Reference: Septic System Design Revision
Starwood Subdivision – Lot 77

Lot 77, Starwood Subdivision

On-Site Wastewater Design Specifications

# Lot 77, Starwood Subdivision

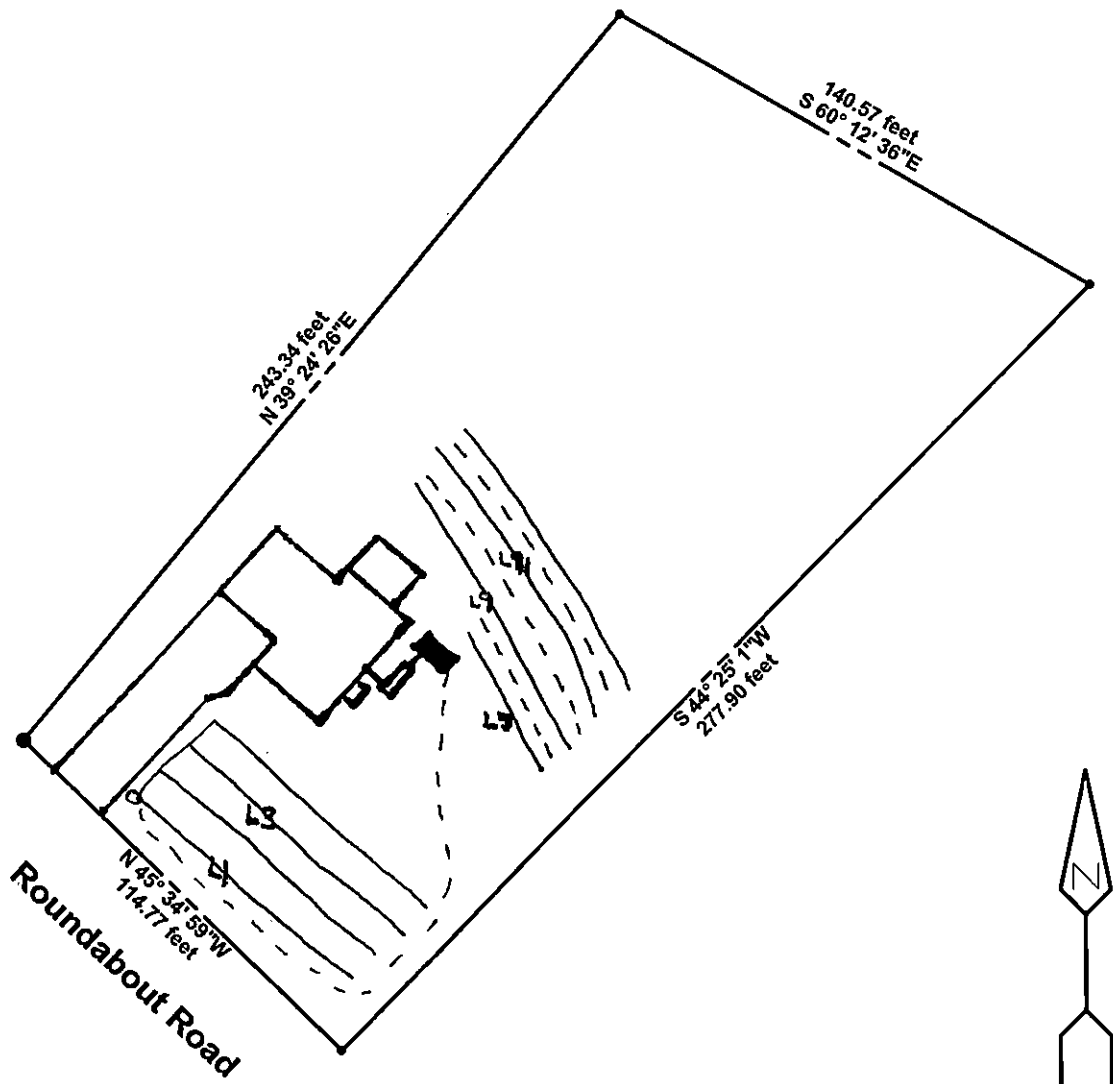
The following revision for Lot 77 is for the repair drainfield which appears to have gone off of the property in our previous submittal due to vague markings of the property line on the right side. This correction has not affected the layout of the initial system except for the location and/or orientation of the septic and pump tanks. The repair septic system is still a low-pressure pipe design just in a different configuration.

Initial System: 4 x 75' pump conventional
off contour at: 18 to 24 inches
LTAR: 0.4 gpd/sqft
Repair System: low-pressure pipe (480 ft)
on contour at: 12 inches
LTAR: 0.12 gpd/sqft
